KITTITAS COUNTY

MEMORANDUM

TO: Community Development Services
FROM: Candie Leader, Administrative Assistant
DATE: September 30, 2019
SUBJECT: BLA BL-19-00018 (Carney)

Please see below our comments regarding the Carney Boundary Line Adjustment (BL-19-00018).

DRAWING TYPE RECORD OF SURVEY

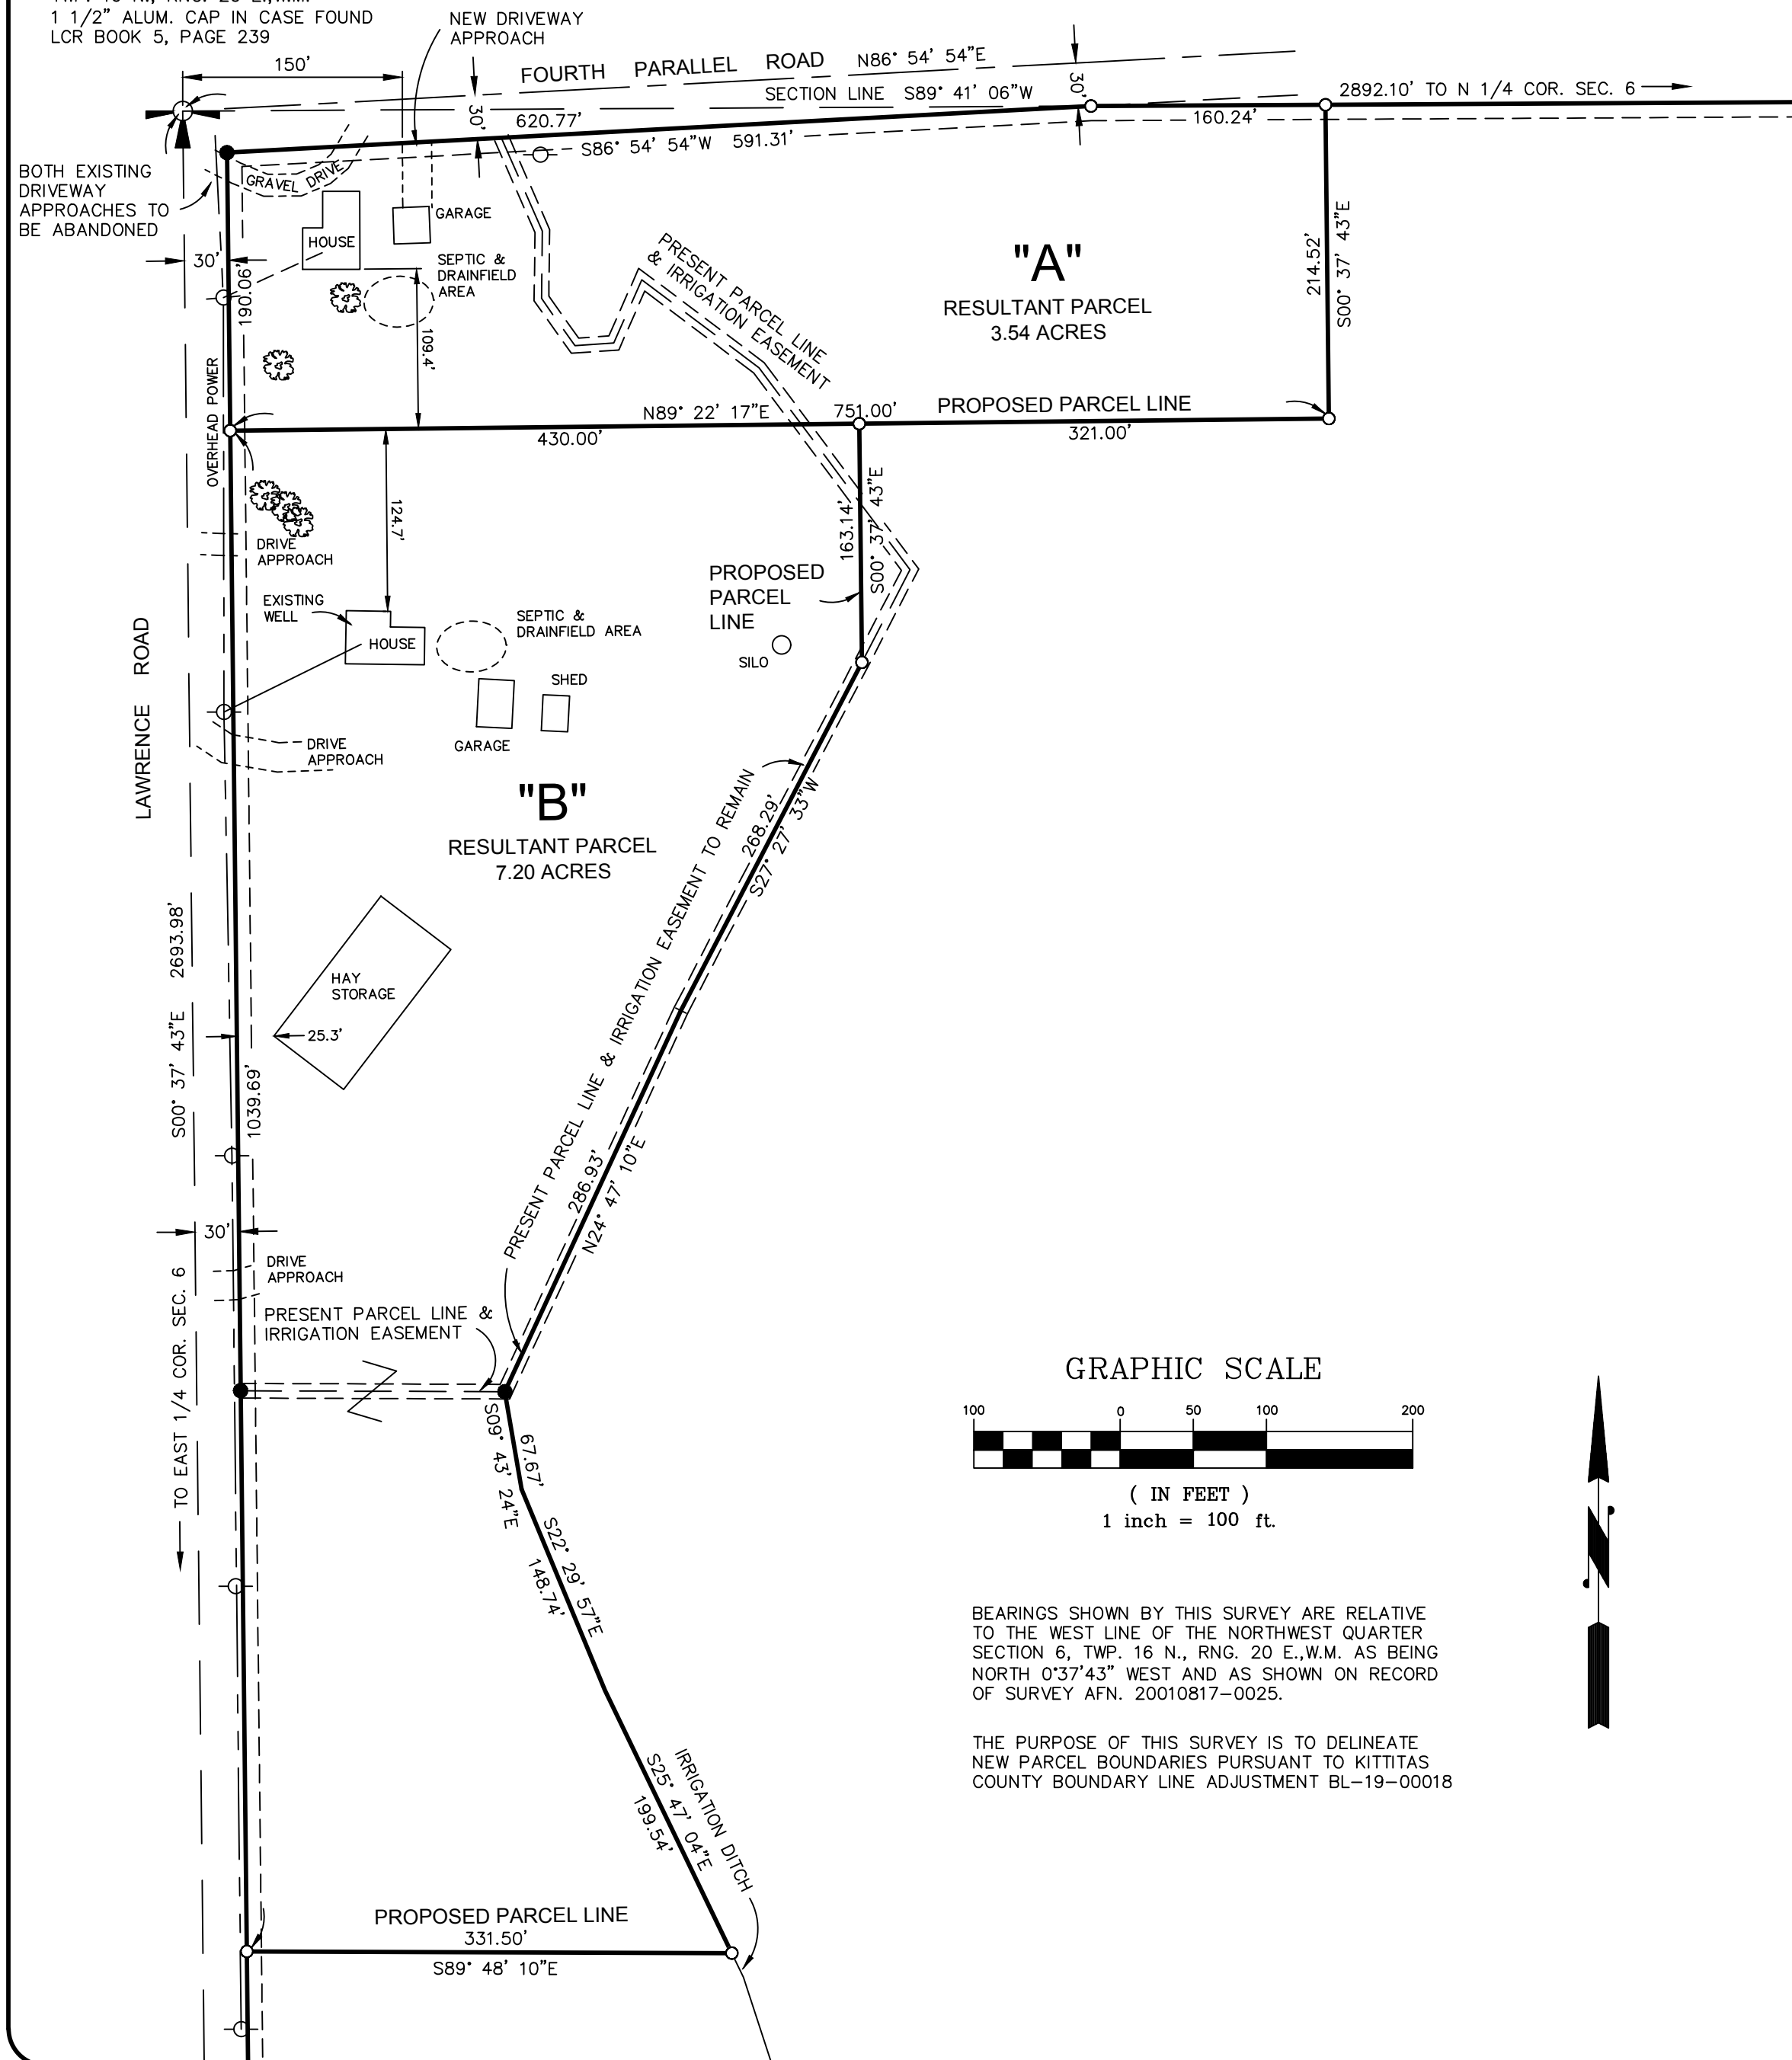
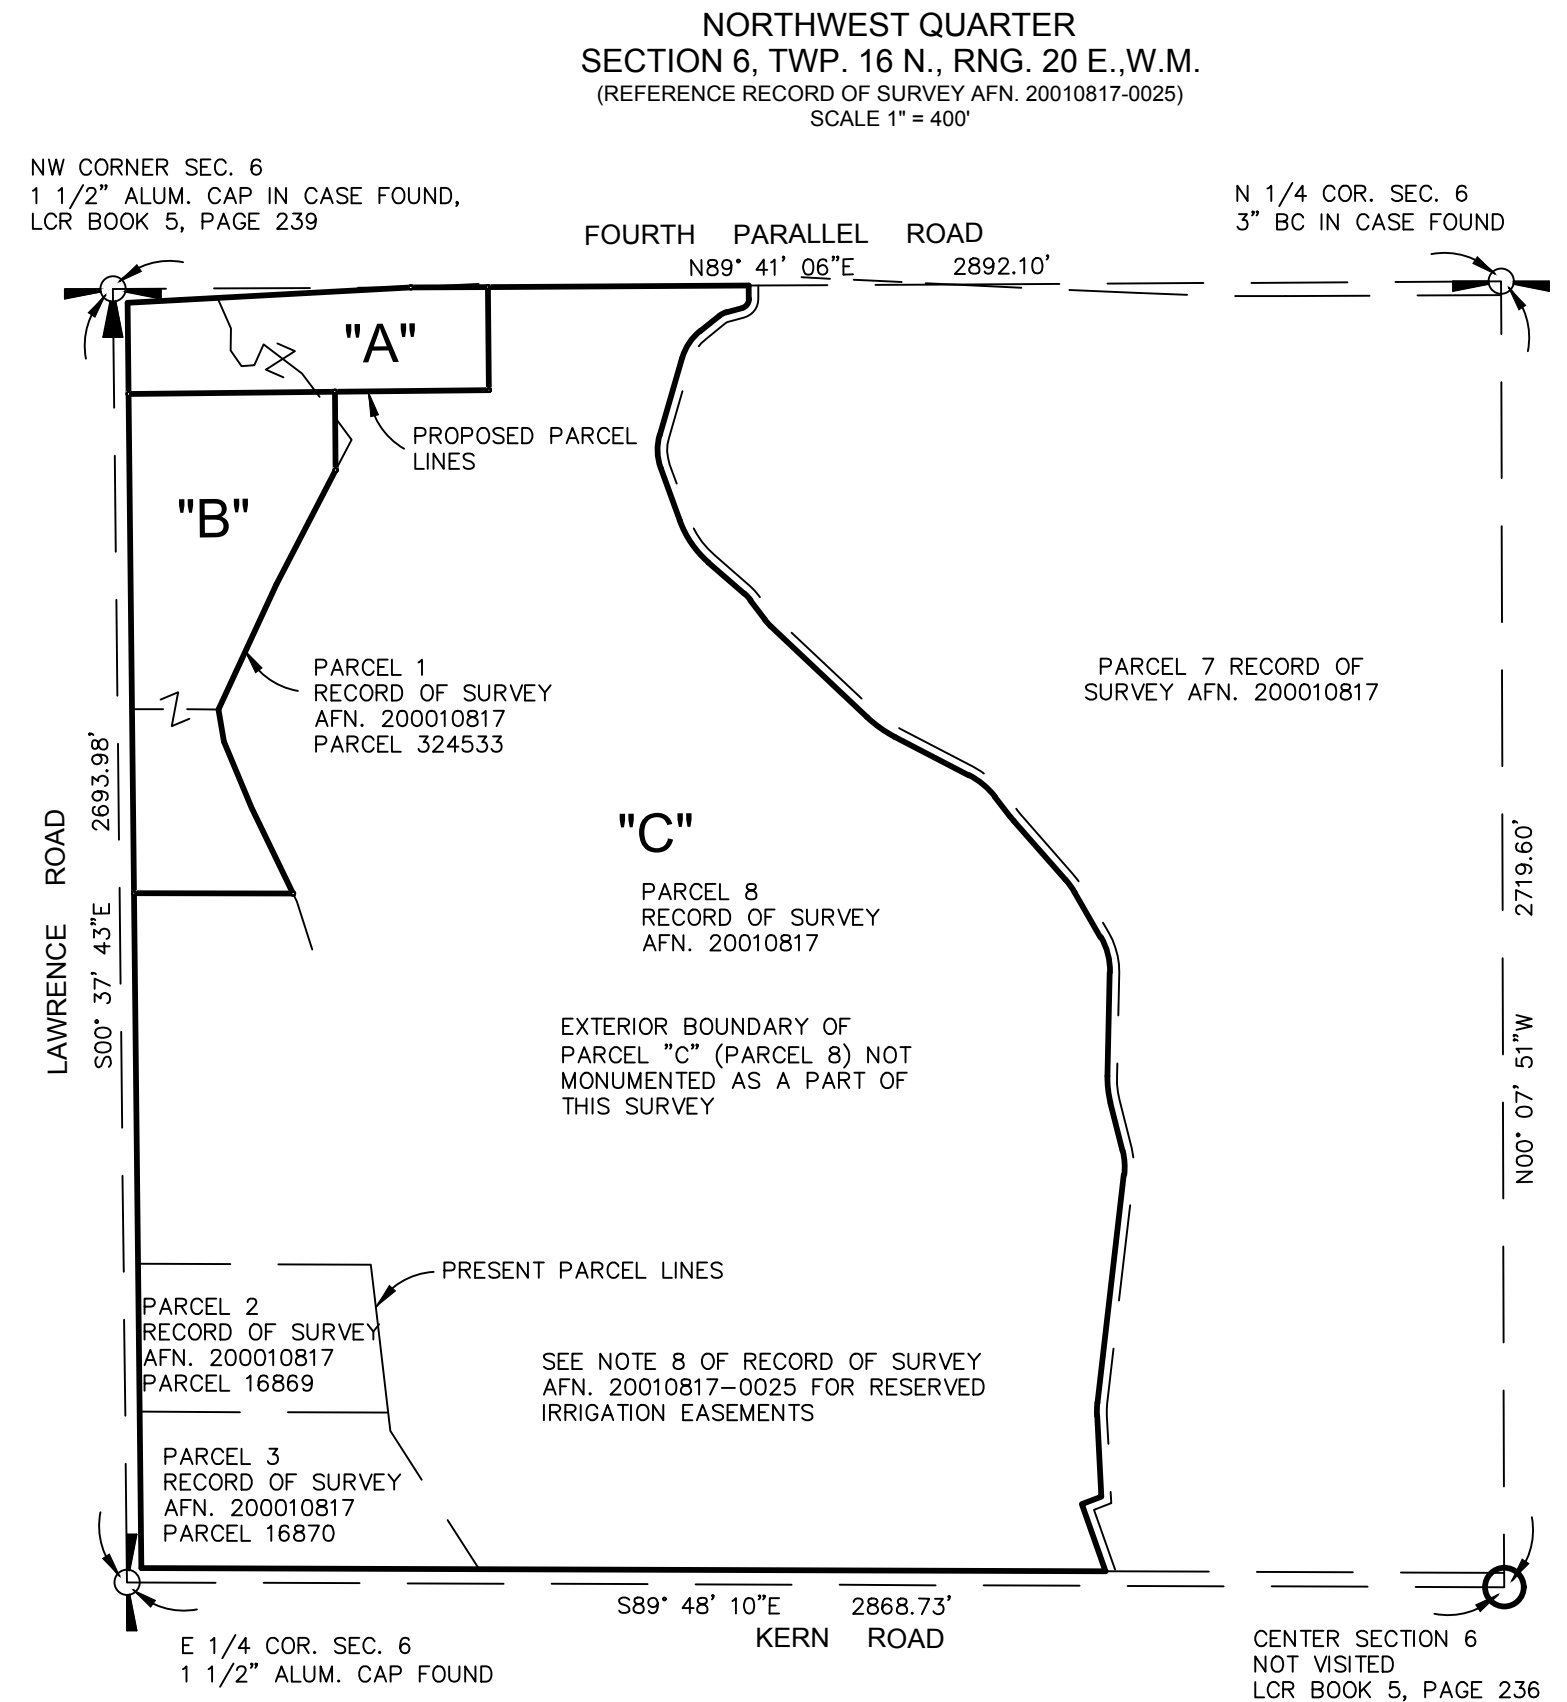
1. A revised legal description that describes the final configuration of the subject property shall be required.
2. A survey map for review
3. Show access easements on the face of the BLA

1. All roadways should show name, width, and underlying ownership.
(EX: Fourth Parallel Rd – 60' County R/W – Paved)
2. At minimum, the new division lines between the parcels should be staked in the field, with set corners shown on the face of the map.
3. The purpose of the survey shall be noted on the face of the map.
(EX: The purpose of the survey is to delineate new parcel boundaries for Boundary Line Adjustment BL-19-00018.)
4. The Record of Survey referenced on Section Map located East of Parcel C is incorrect.
5. Typo on "Preliminary" within title block.
6. Section Township and Range Shall be shown in Bold text near the top of the page
(EX: Pt of NW 1/4 Sec 6, T16N., R20E, W.M.)
7. Location within title block does not encompass all of the proposed BLA.
